Rezoning Transportation Analysis

Petition Number: 2019-156

| Date | Description |
|------------|--------------------|
| 05-14-2020 | Third Review |

JOB NO. 44497  
SHEET NO. RZ100

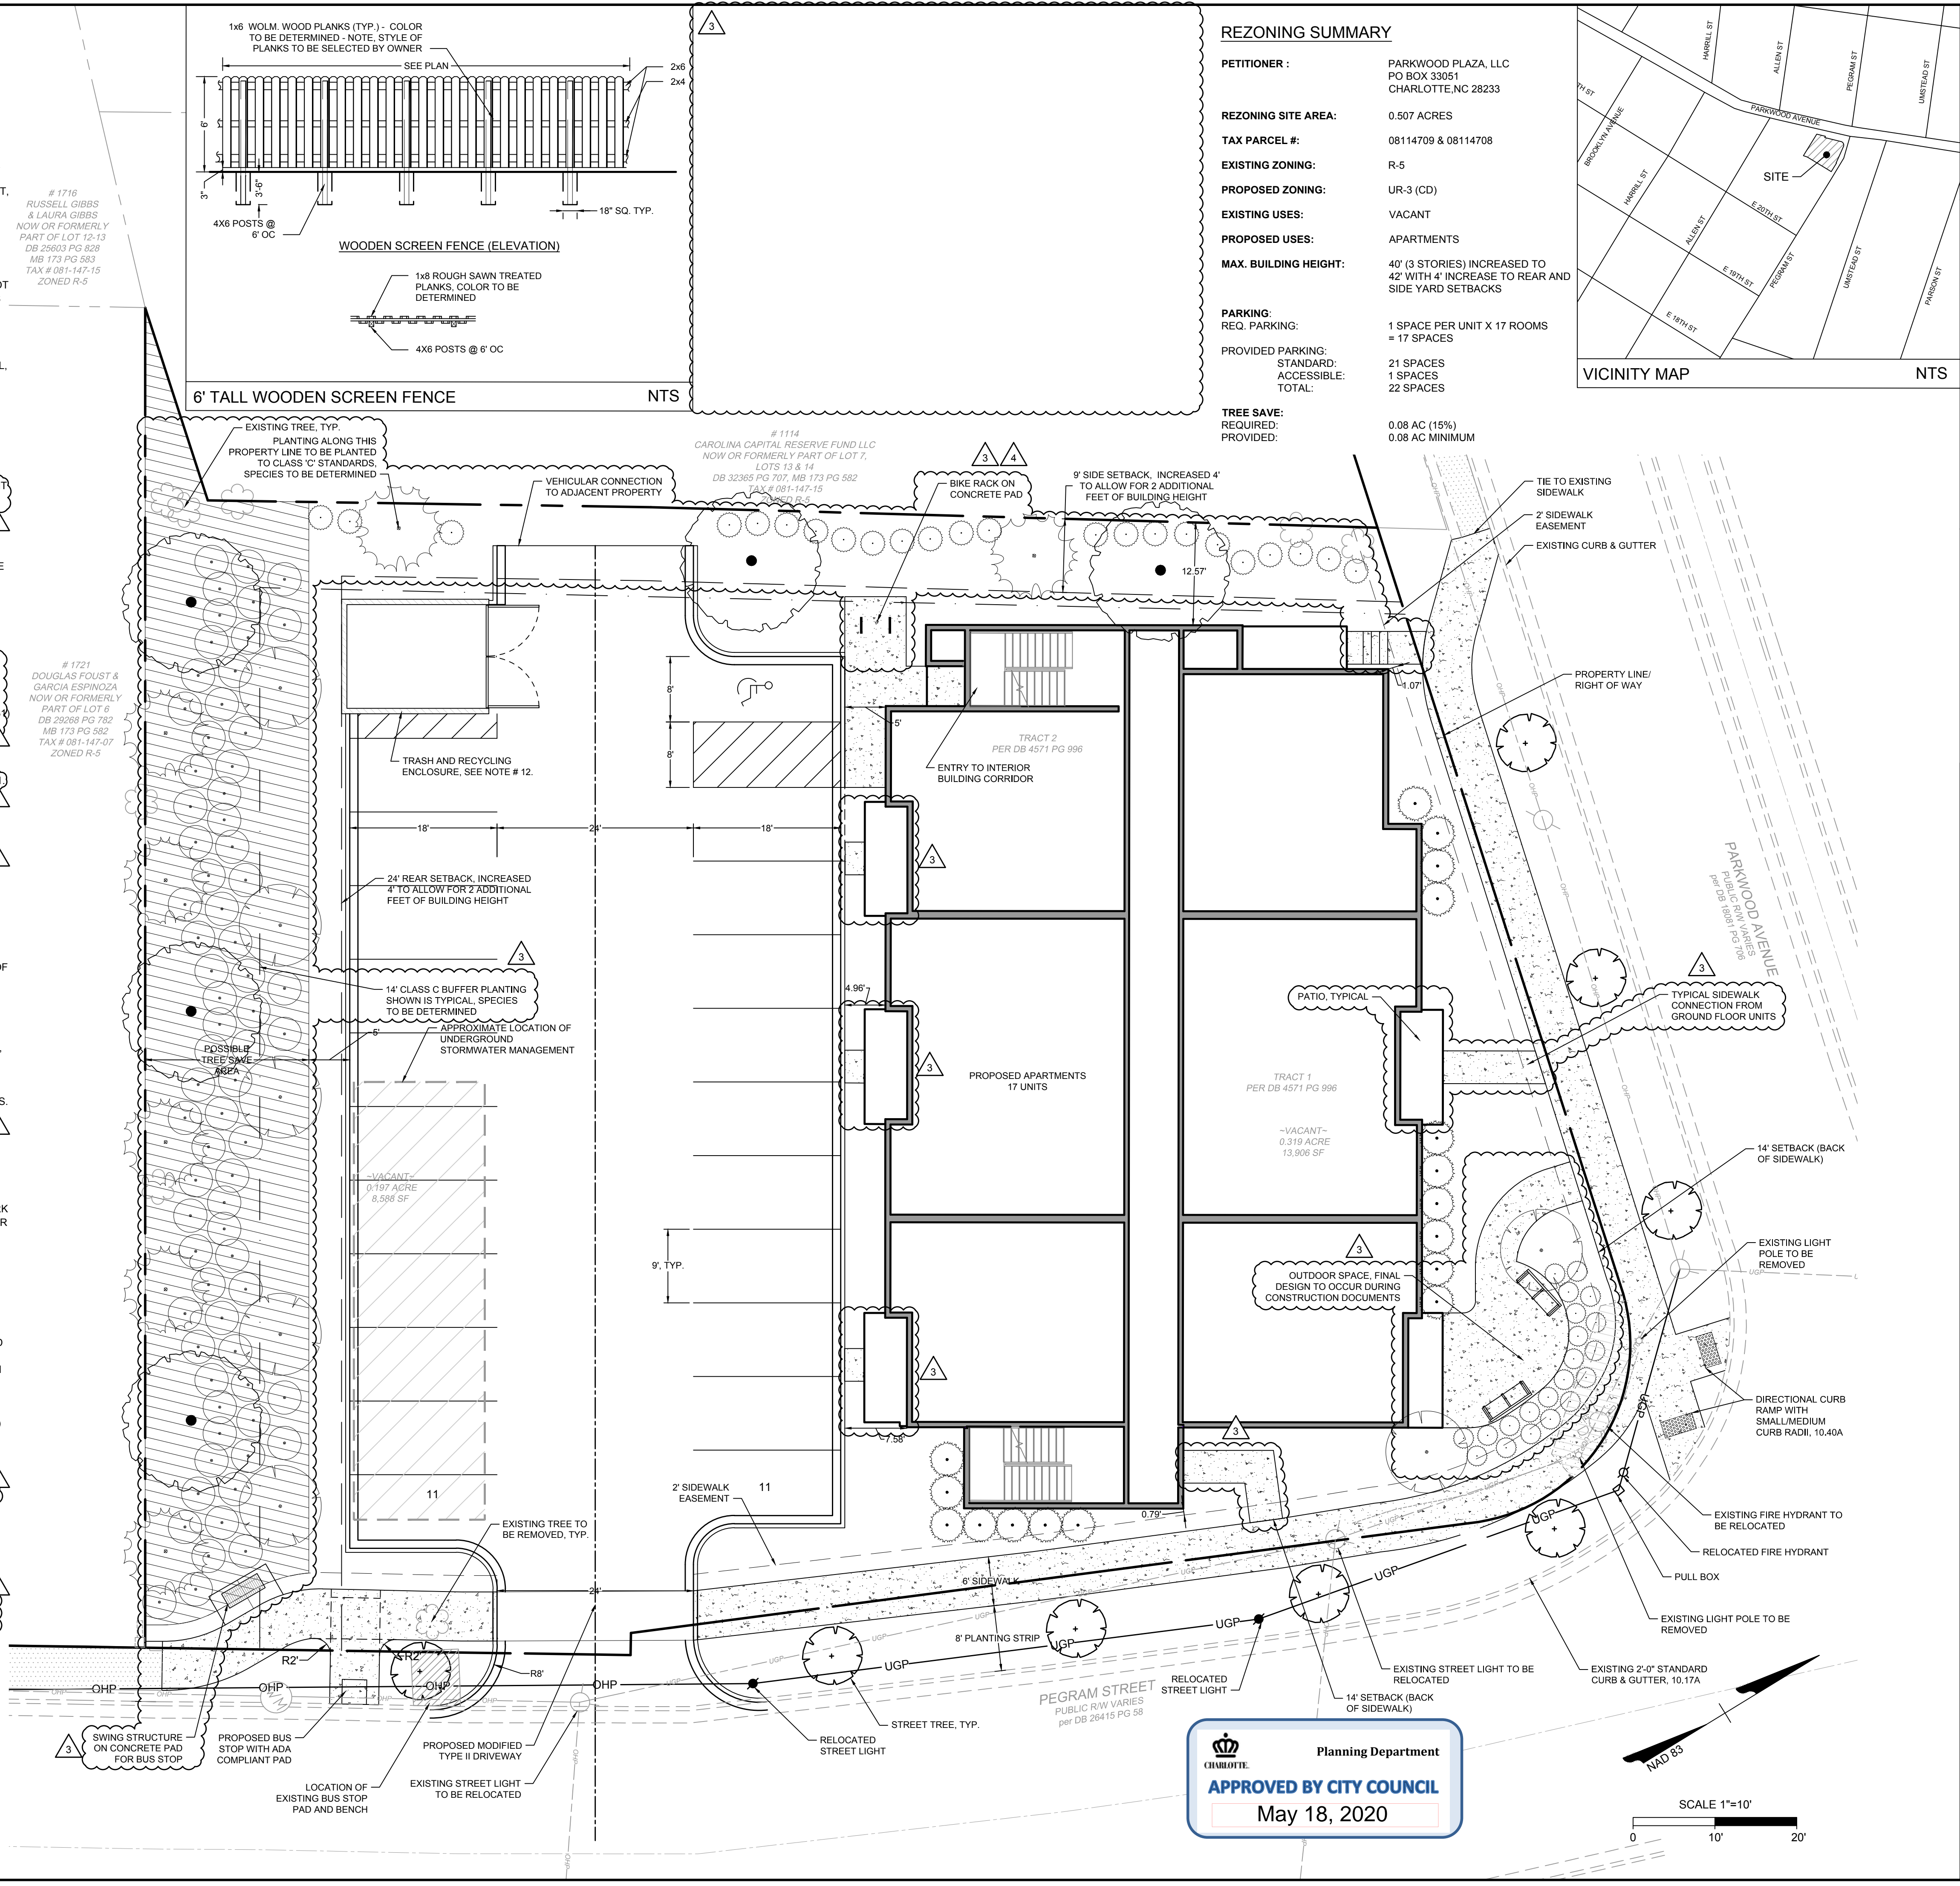
~~The site plan should show the curb and gutter labeled and dimensioned from the centerline for each road.~~
- ~~**Traffic Study** A Traffic Impact Study is not necessary for the complete review of this petition.~~
- ~~The petitioner should revise the site plan and conditional note(s) to commit to construct two directional ramps at the intersection of Parkwood Avenue and Pegram Street, per the *Parkwood (N. Davidson – The Plaza) Improvements* construction plans. Please refer to these plans within the rezoning site plan and conditional note(s). The *Parkwood (N. Davidson – The Plaza)* plans are available upon request.~~

4. ~~The petitioner should revise the site plan and conditional note(s) to remove the truncated domes and to continue the sidewalk at grade across the driveway.~~

5. ~~The petitioner should revise the site plan to add a note specifying dedication and fee simple conveyance of all rights of way to the City before the site's first building certificate of occupancy is issued. CDOT requests right of way set at 2 feet behind the back of sidewalk where feasible.~~

6. ~~The petitioner should revise the site plan and conditional note(s) to include utility easements where underground conduit is placed outside of the public r/w for the relocated street lights. The petitioner should commit to upgrading the street lighting along the site's right-of-way frontage to LED. Coordinate with Patrick Monroe (Patrick.Monroe@ci.charlotte.nc.us at 704-336-3937).~~

7. ~~The petitioner should revise the site plan and conditional note(s) to clearly define the on-site ordinance required bicycle parking.~~
